PLANNING APPLICATION REF. R/114/15/HH. 81 Sea Avenue, Rustington.

I am writing to state my objections to the above planning application.

PROPOSED FLOOR PLANS 1:50

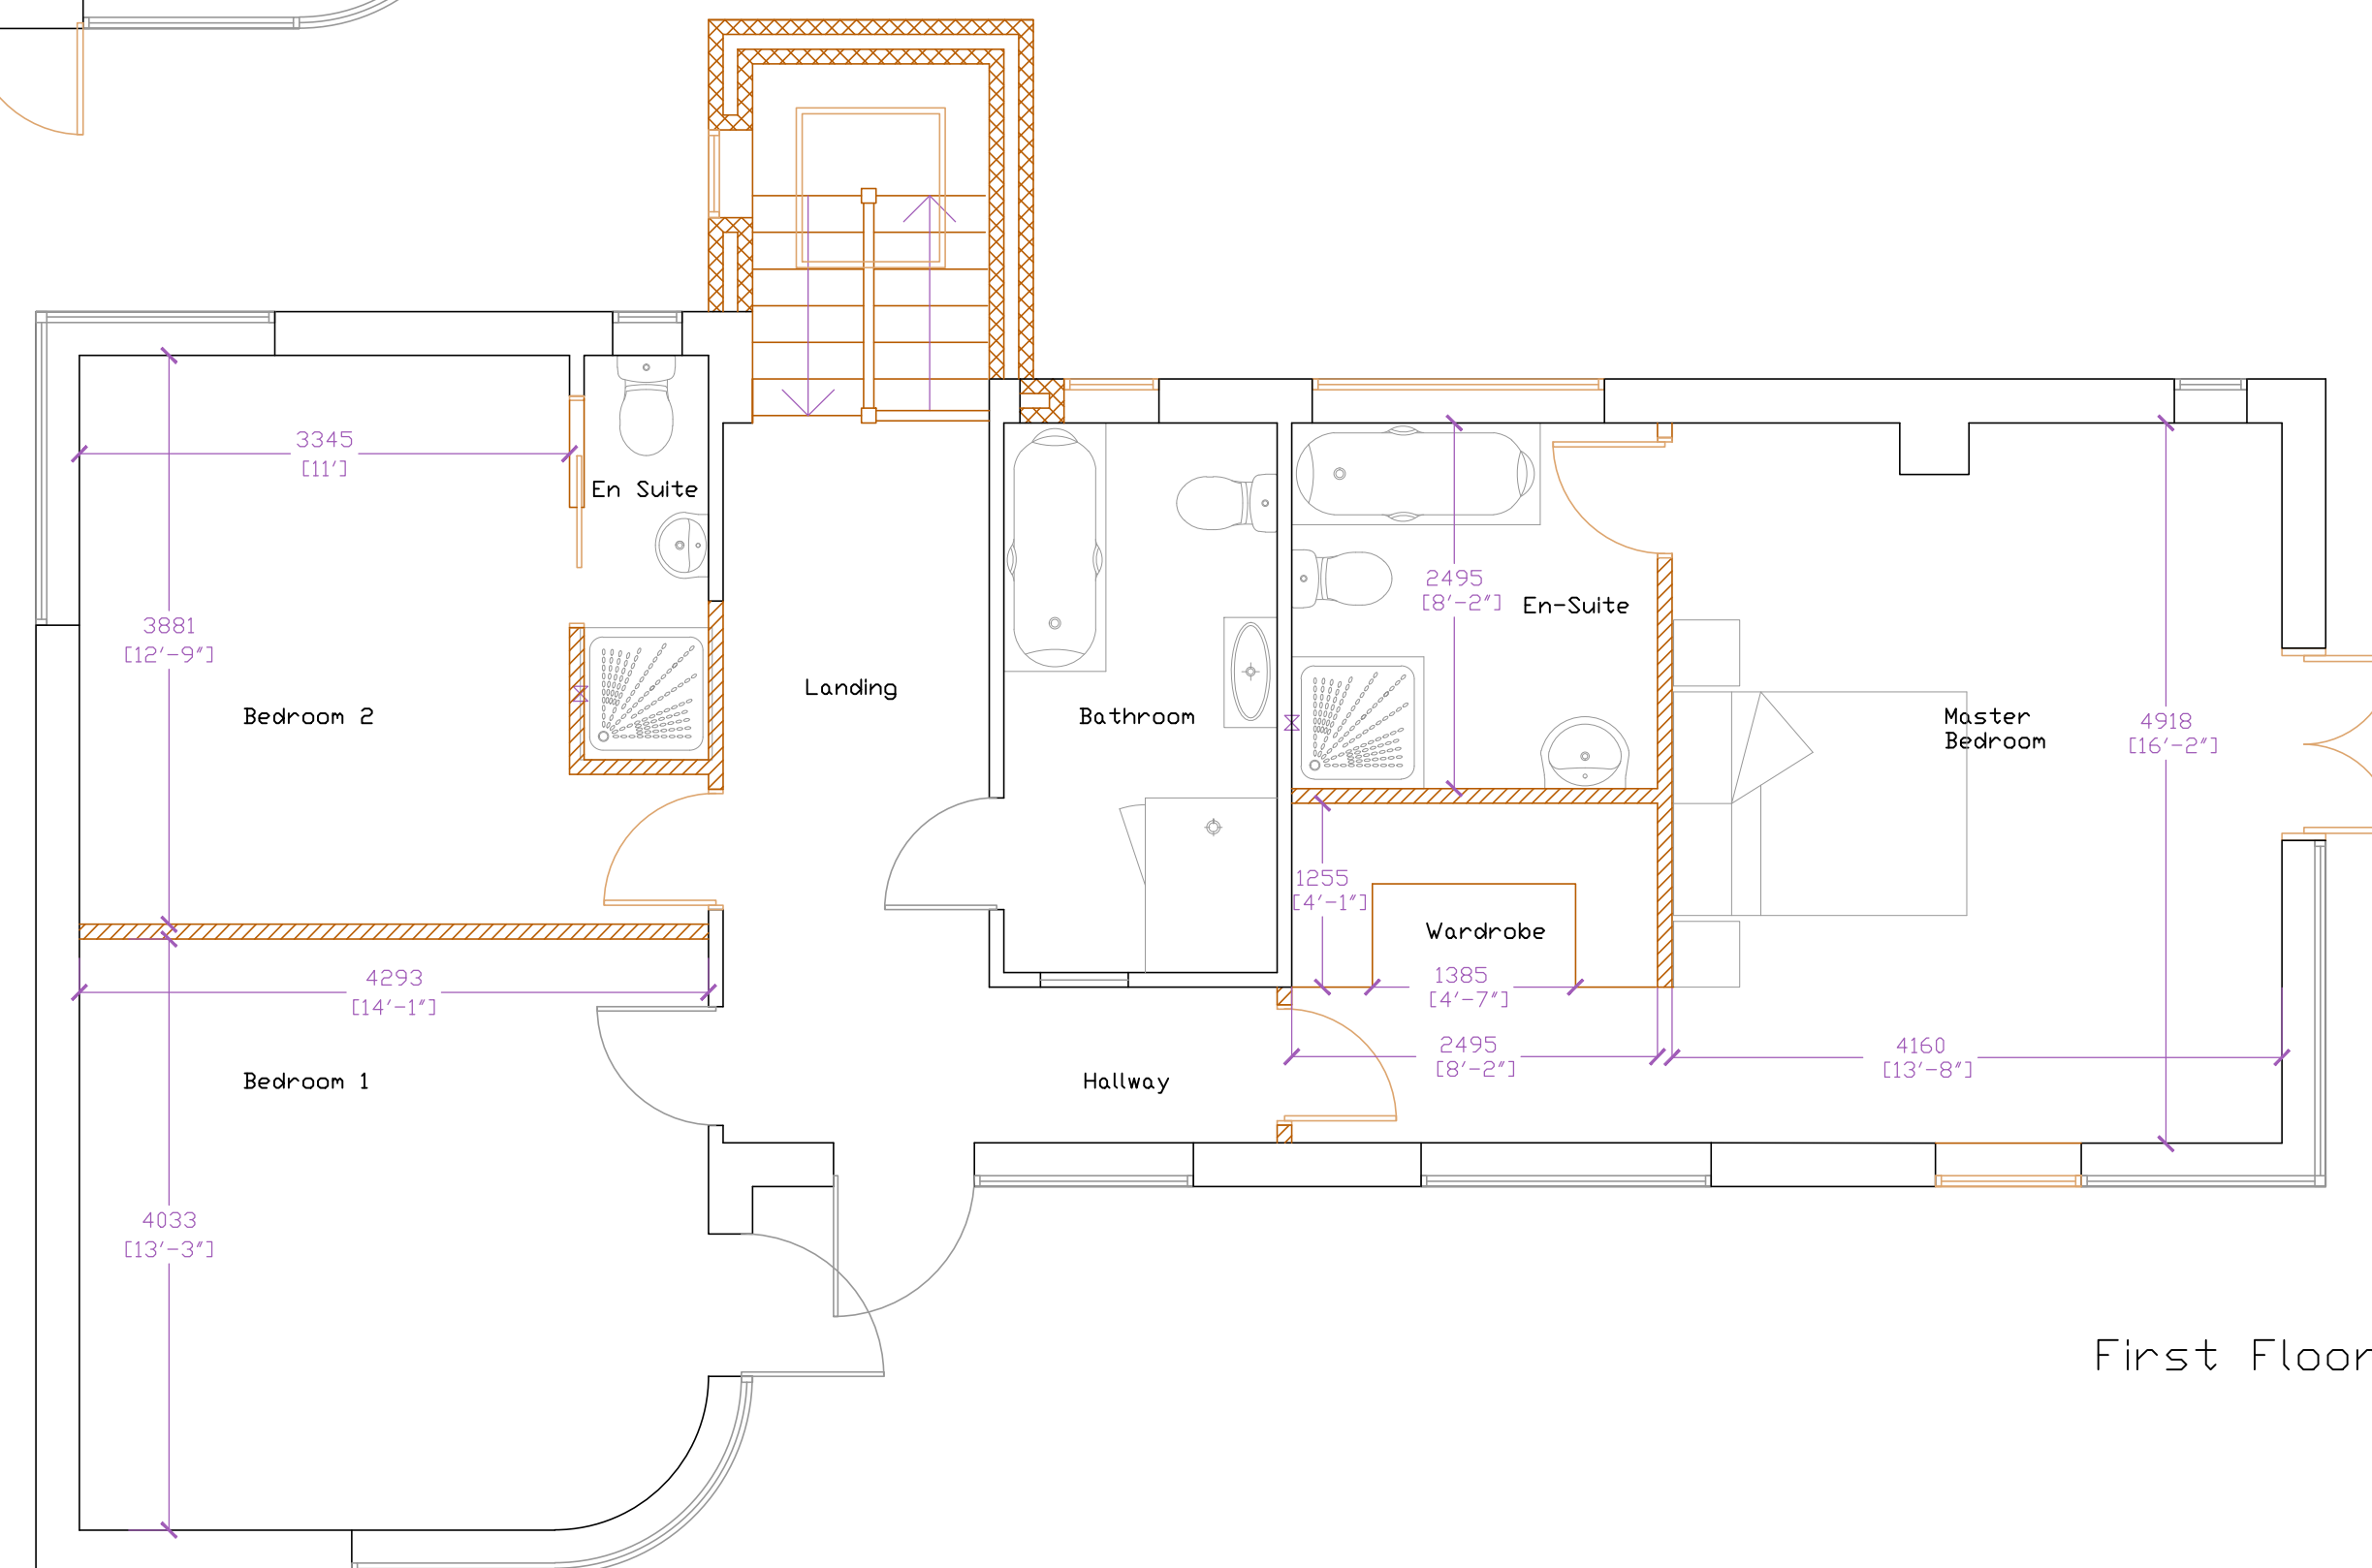
4. Garage facilities. The proposal would remove the present garage from the property and not replace it. There is a consequent risk that vehicles would be parked on Sea Avenue or in The Thatchway, which would be out of keeping with the area. Nearly all the properties on the Estate have garage facilities. Furthermore, parking within 25 yards of the junction of Sea Avenue and The Thatchway would constitute a breach of the Highway Code.
